STATE OF NORTH CAROLINA  
DEPARTMENT OF TRANSPORTATION

July 3, 2013

**Subject:** Post Field Meeting Addendum to March 22, 2013 Request for Modifications to the Section 404 Individual Permit and Section 401 Water Quality Certification for I-485. Division 10, TIP's R-2248 E and R-2123 CE, Debit \$570 from WBS 34410.3.GV2

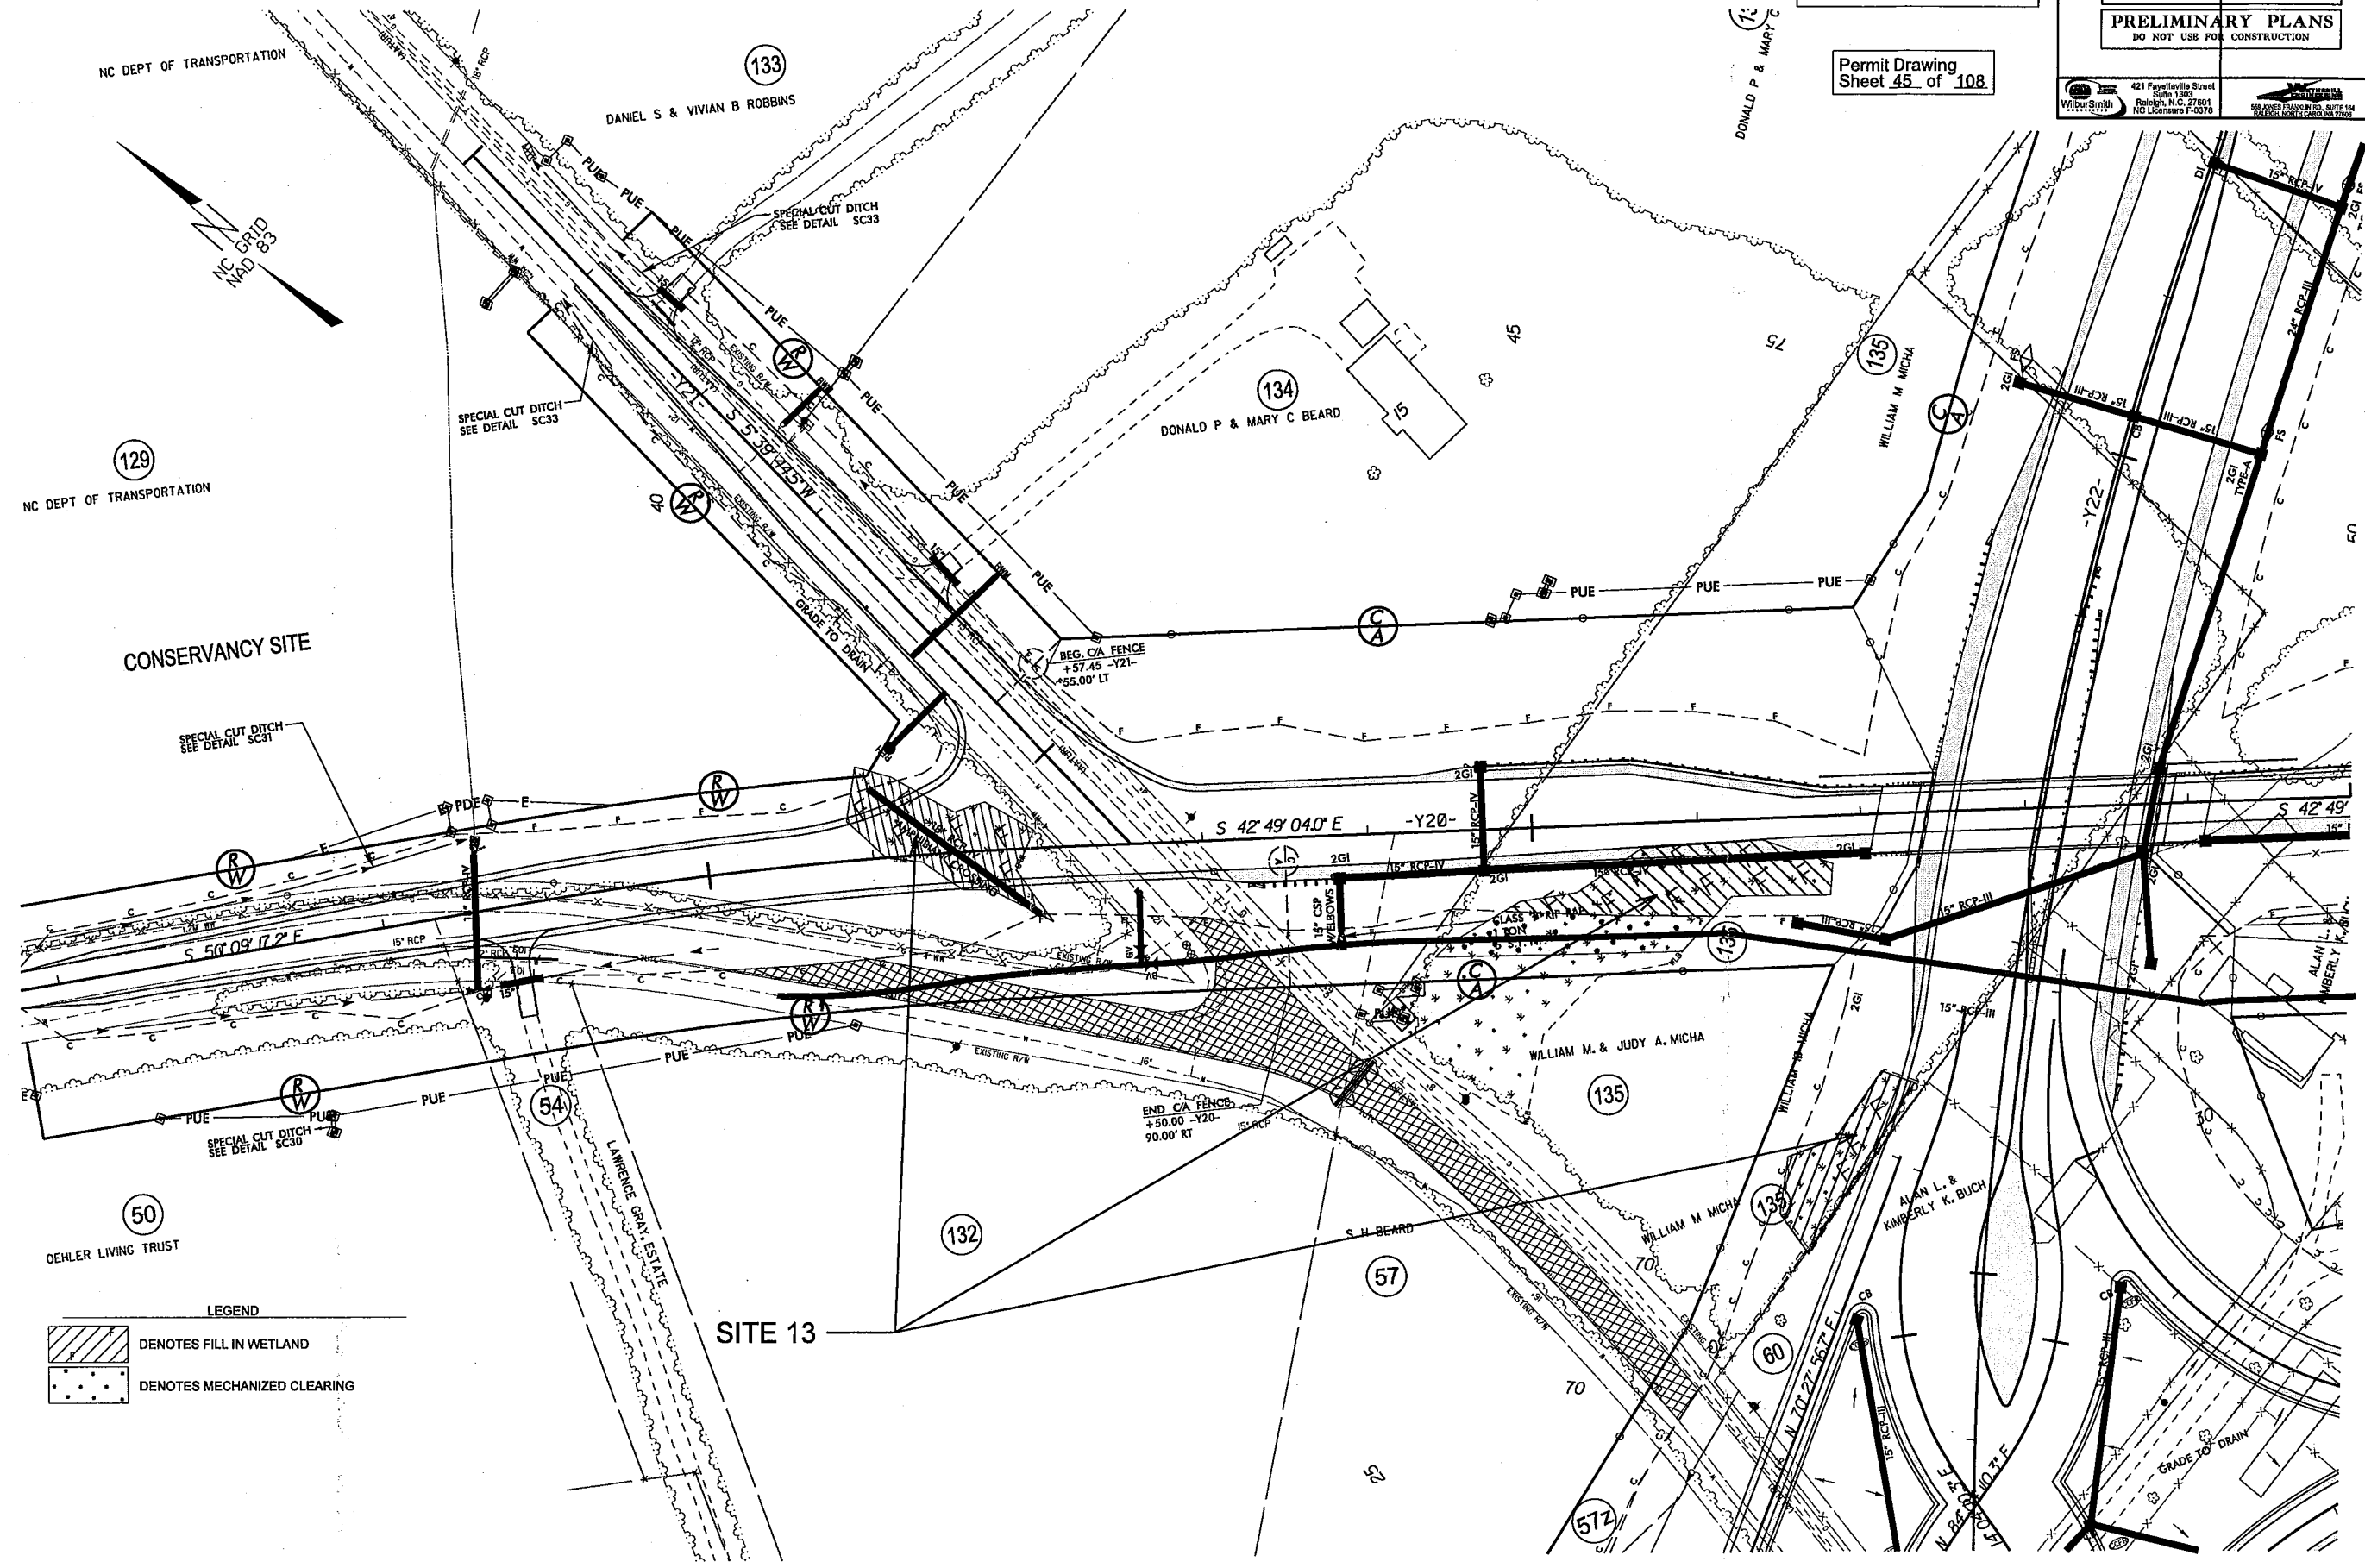
Site 13 – Water Line Impact Changes (non-riparian wetlands)

The newly described 16-inch water line from the March 22, 2013 modification request is being placed closer to the roadway in an area designated as "mechanized clearing" rather than a new impact of "excavation". Therefore, the request from the March 22, 2013 for additional mitigation of 0.09 acre of mechanized clearing (from 0.03 to 0.12 acre), and 0.03 acre of excavation (0.0 to 0.03 acre), will no longer be required. The impact will revert back to the previous amounts accounted for in the November 2011 permit, of 0.03 acre of mechanized clearing and no excavation. The drawing has been revised to depict the permanent fill, and included in this modification request (see attached Permit Drawings Sheet 45 of 108).

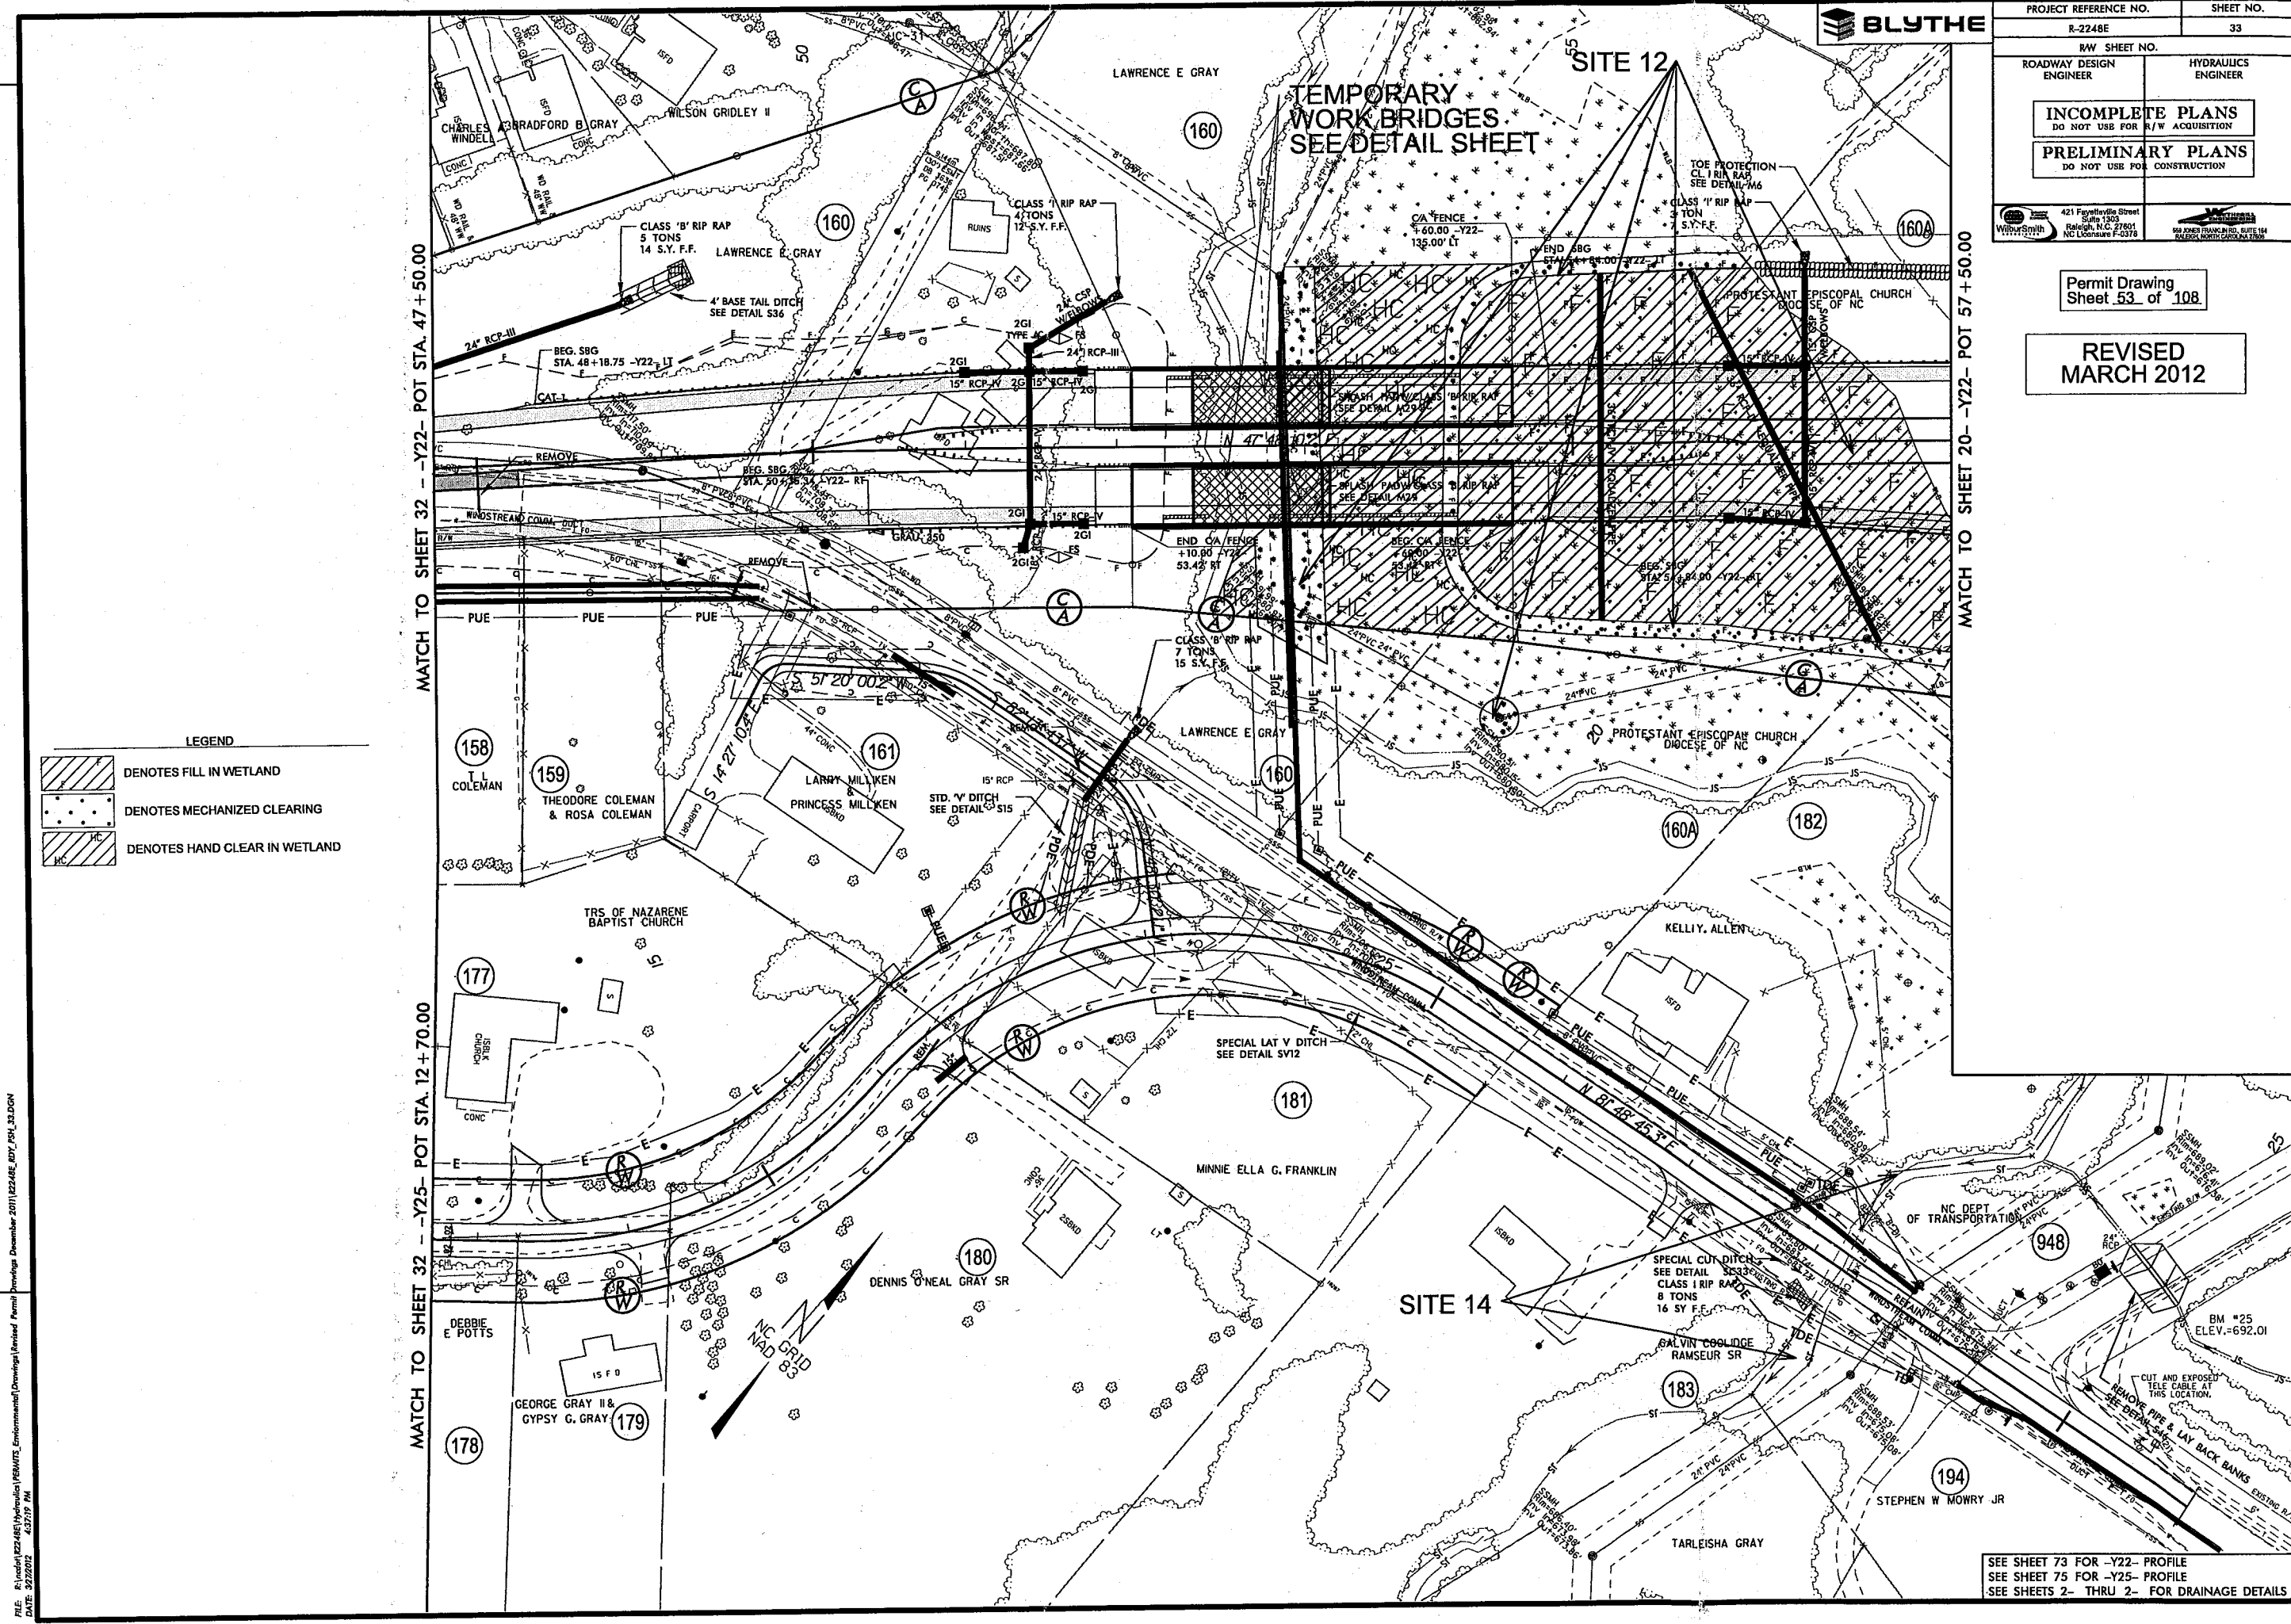
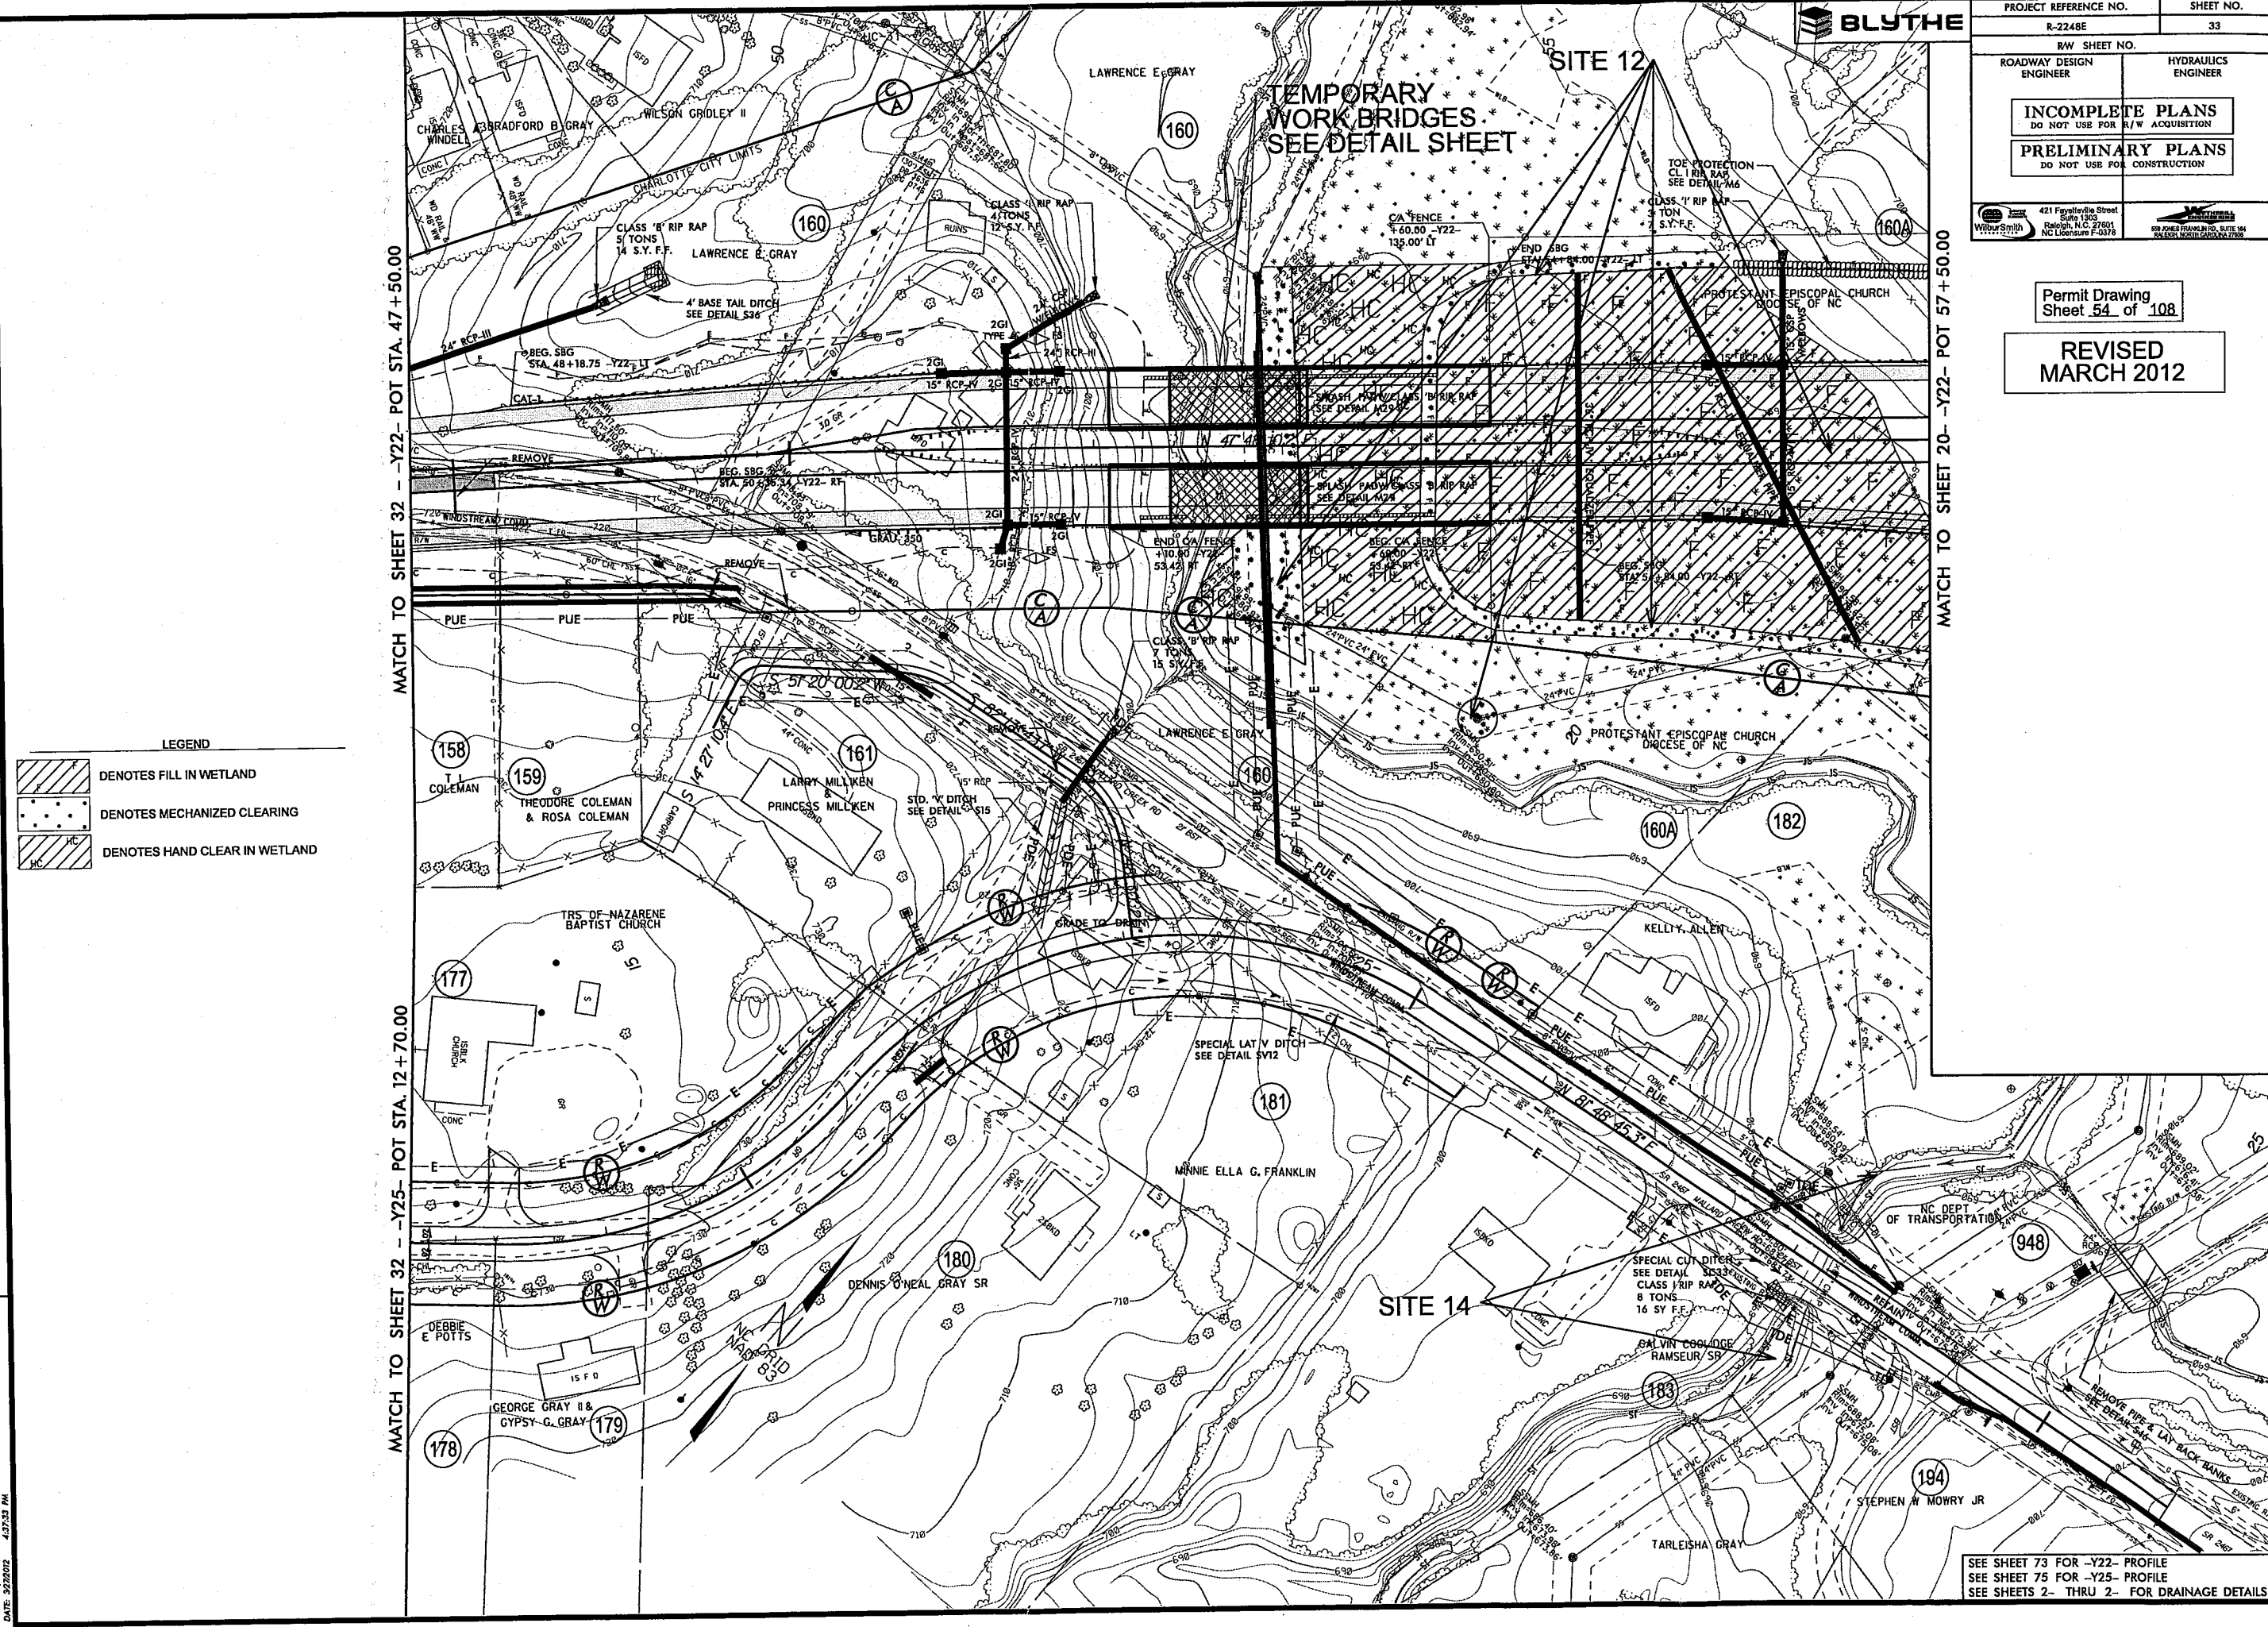
Site 12 – Sewer Line Impact Changes

The sewer line utility impacts depicted on the March 22, 2013 modification request are not required, as the new sewer line was able to tie back into the existing line at an earlier junction. Impacts will not change at this site. The previous drawing (dated March 2012), submitted with the June 2012 modification request, is accurate for this site (see attached Permit Drawing Sheet 53 of 108).).
